KIRKLEES METROPOLITAN COUNCIL INVESTMENT & REGENERATION SERVICE

DELEGATED DECISION TO DETERMINE PLANNING APPLICATIONS

Reference No:	2026/62/90193/E
Site Address:	Land adj, 1a, Field Head, Shepley, Huddersfield, HD8 8DR
Description:	Demolition of existing barn and erection of two dwellings
Recommending Officer:	Danielle Cooper

DECISION – CONDITIONAL FULL PERMISSION

first floor

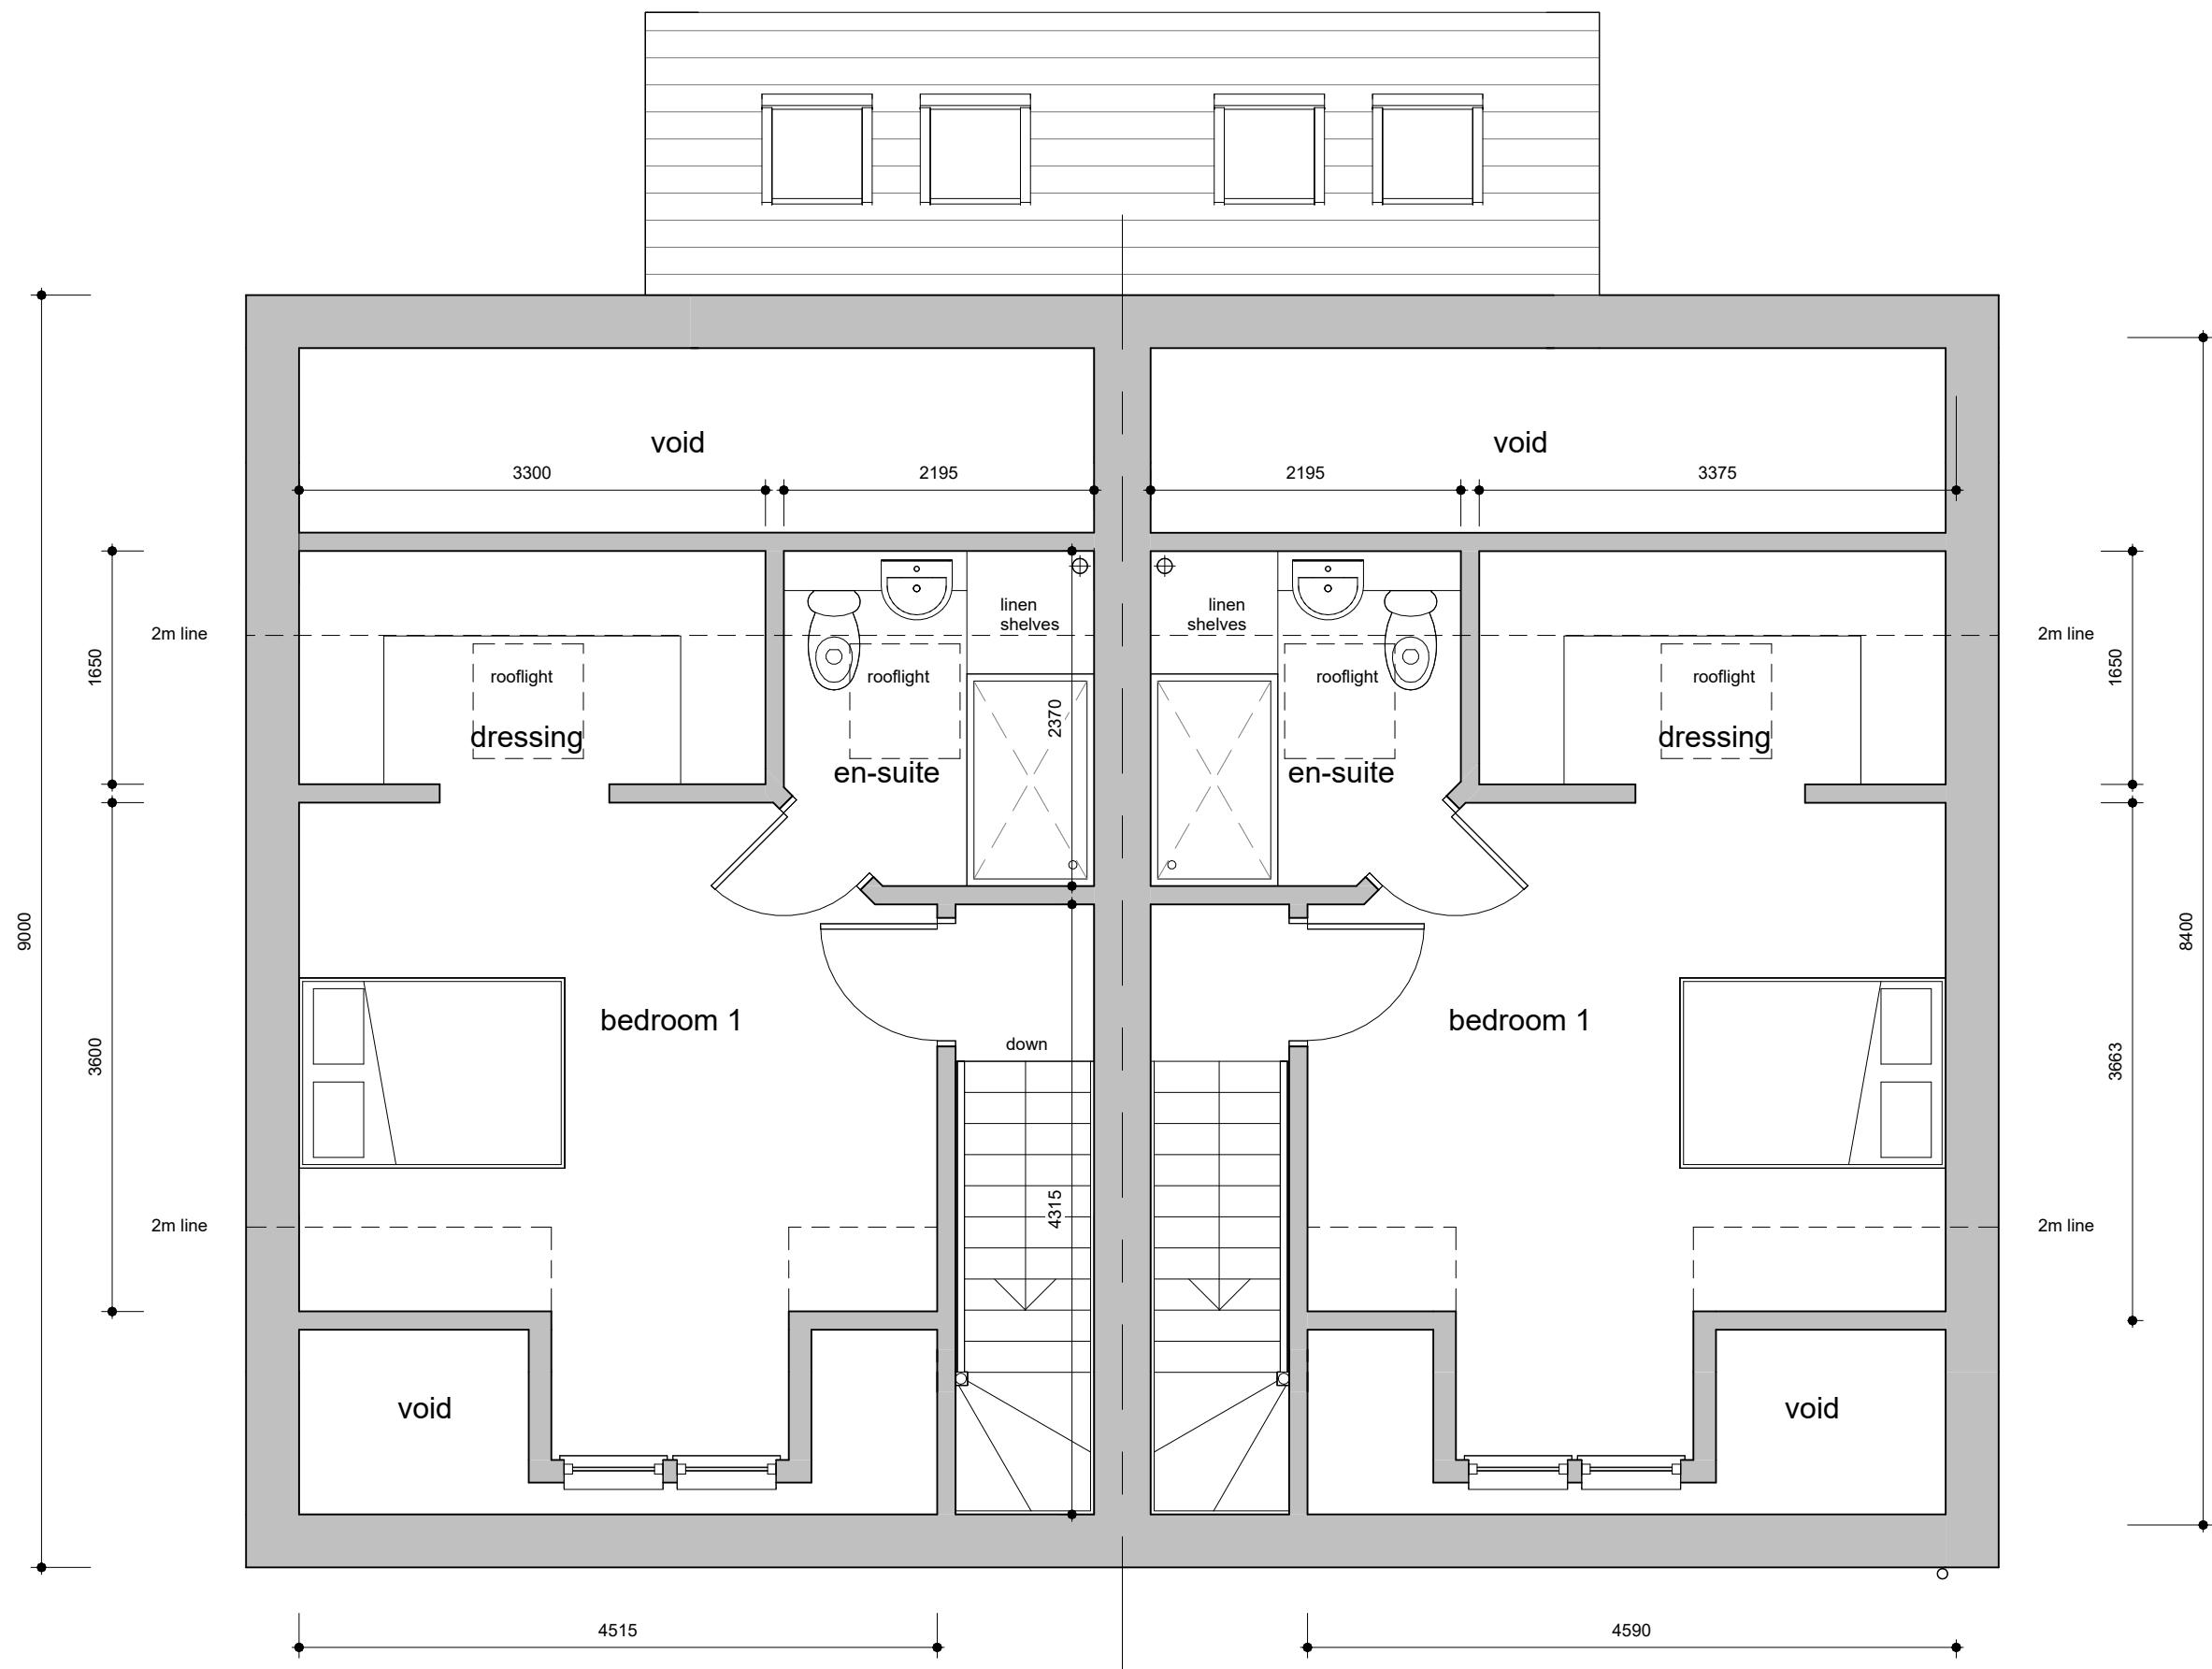
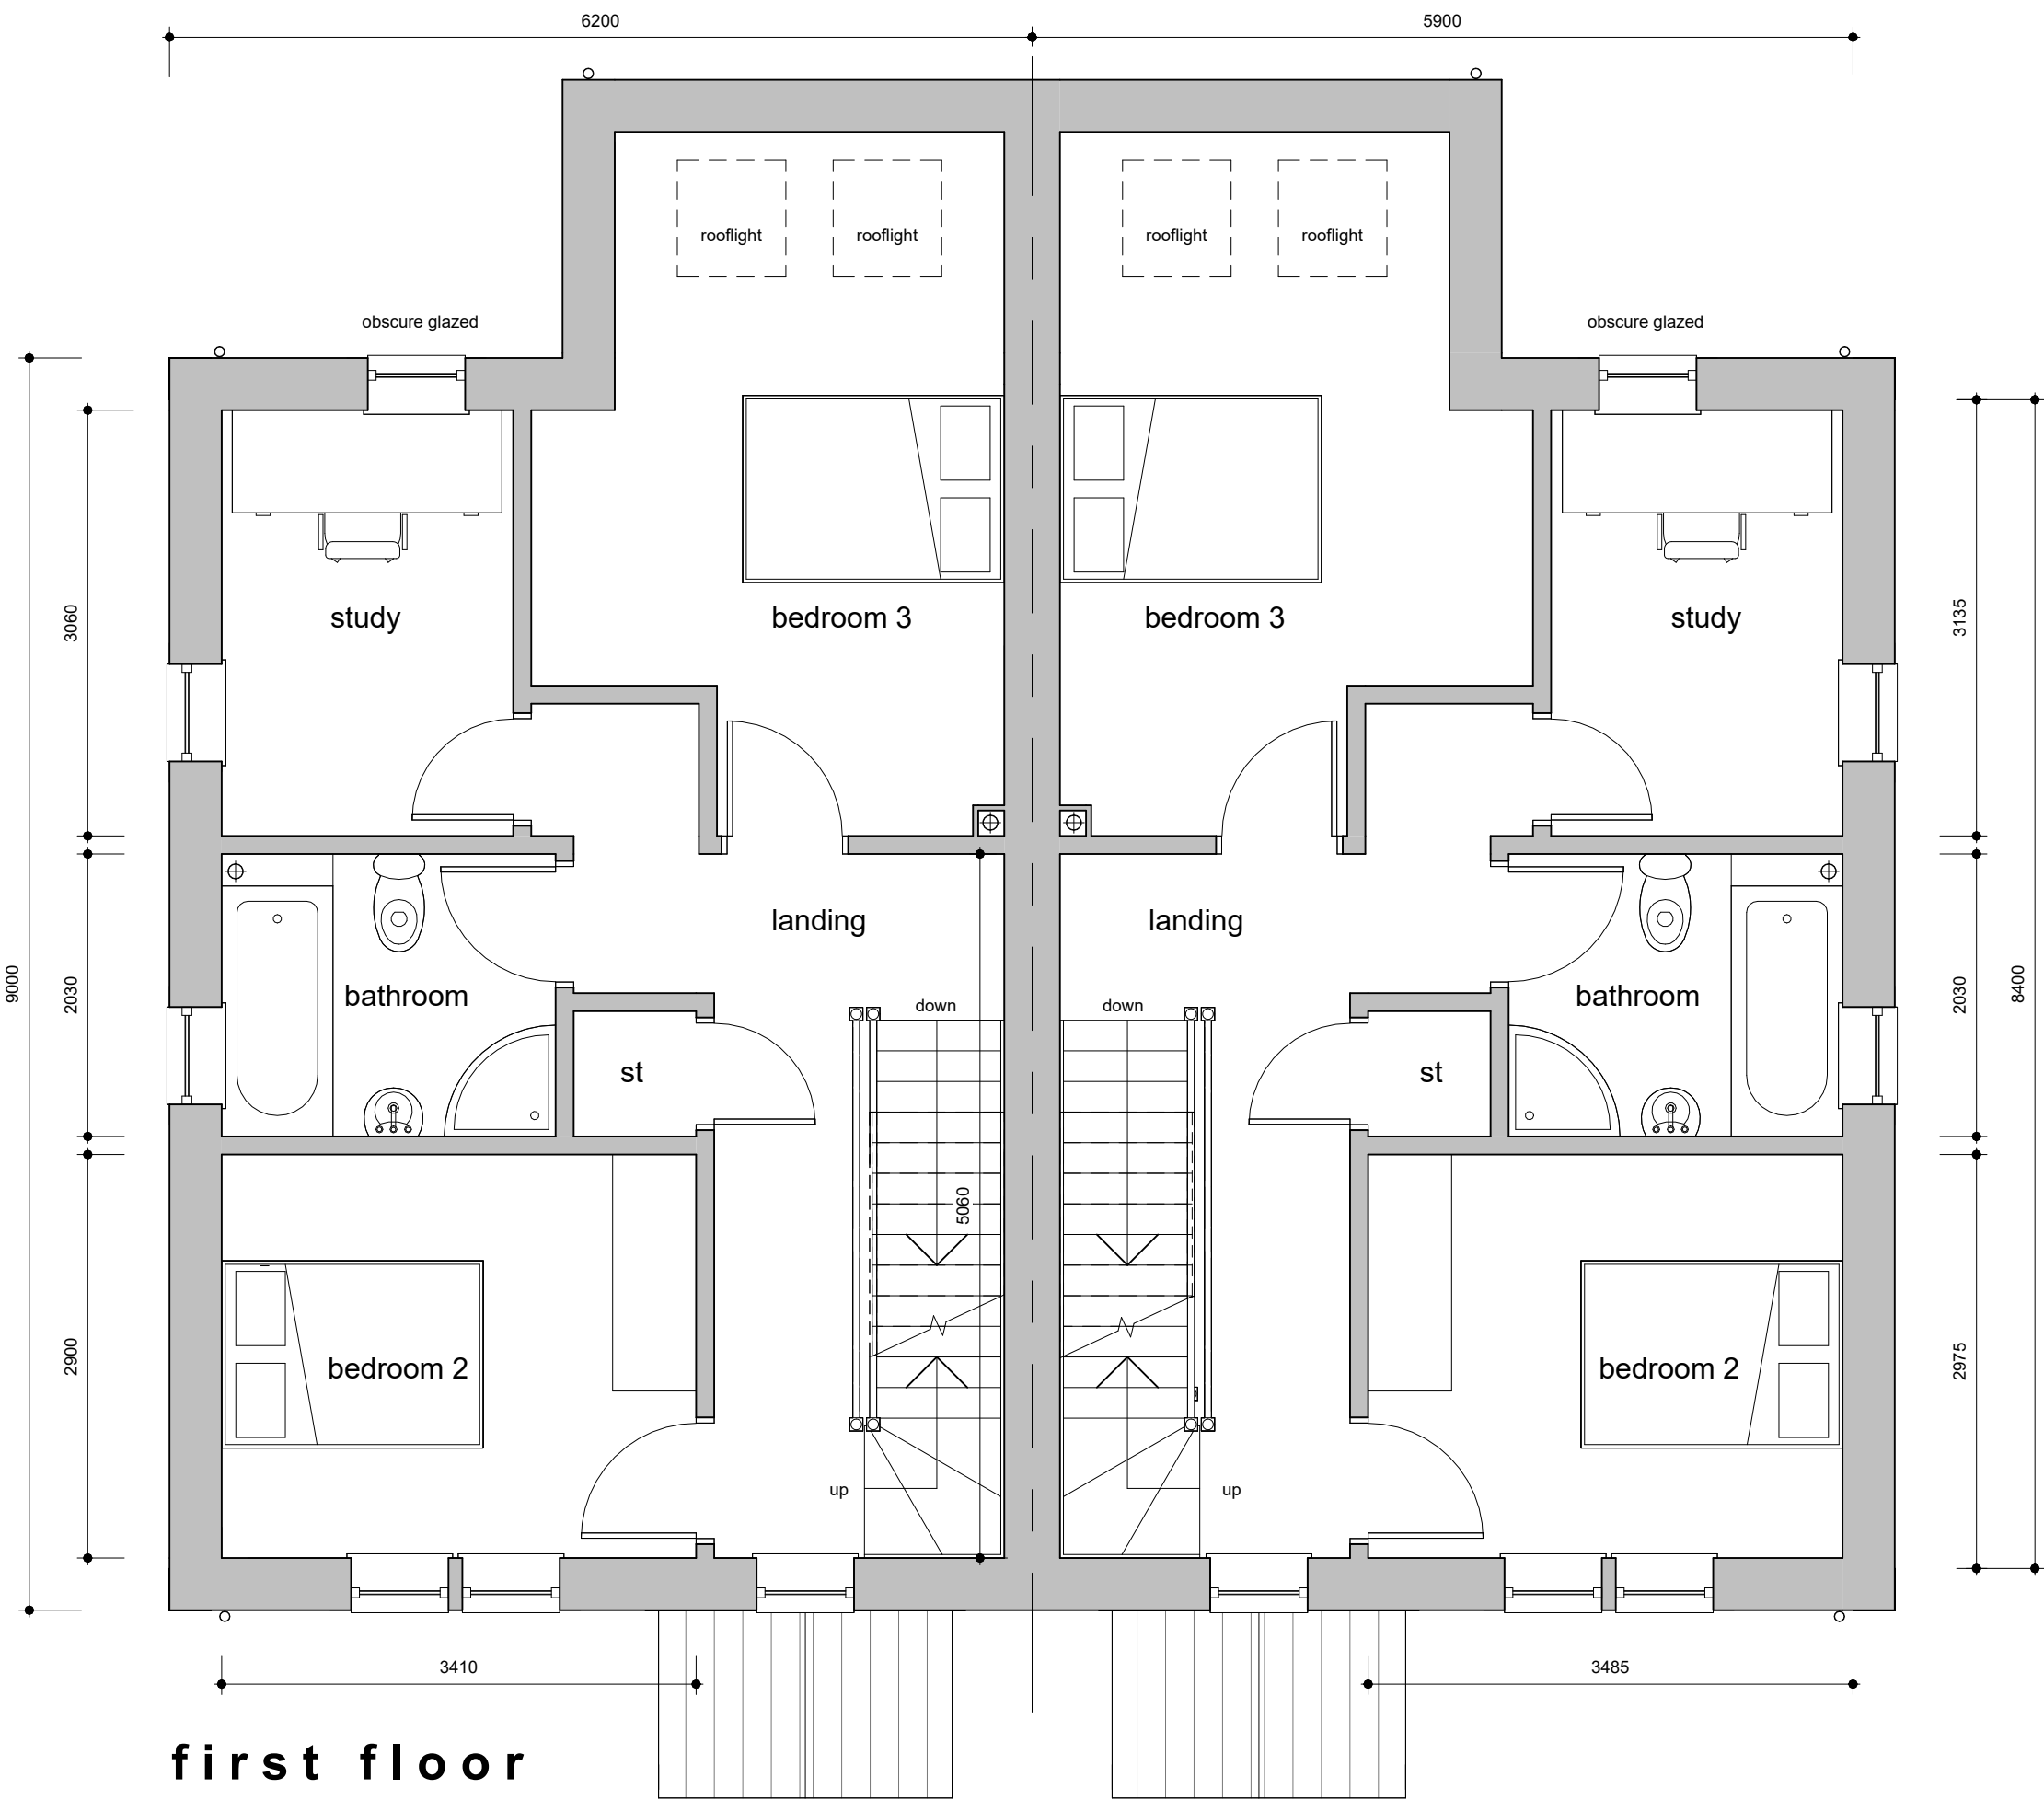
The proposal includes two first floor side windows facing No.1a. One of the first floor side windows would serve a bathroom. As this window relates to a non-habitable room, there are no concerns regarding loss of privacy for the occupants of No. 1a Field Head. The other first floor side window would serve a study. As this window would look directly provide views across the roof of No. 1a Field Head which is a bungalow, there are no concerns to loss of privacy.

The proposal includes two first floor side-facing windows which face towards Nos. 36a and 36b Station Road and 1a Lydgate Road. One of these windows would serve a bathroom, which is a non-habitable room, and therefore it is not considered to give rise to any unacceptable overlooking or loss of privacy for the occupants of the neighbouring properties. The second first-floor side window would serve a study and would provide views towards Nos. 36a and 36b Station Road and 1a Lydgate Road. Whilst it is acknowledged that the separation distance between this window and the neighbouring properties would be approximately 17 metres, falling below the recommended 21-metre distance, the shortfall is considered relatively minor. Given the limited degree of harm identified, it is not considered that the proposal would result in a significant loss of privacy or overlooking sufficient to warrant refusal of the application. The impact is therefore considered acceptable.
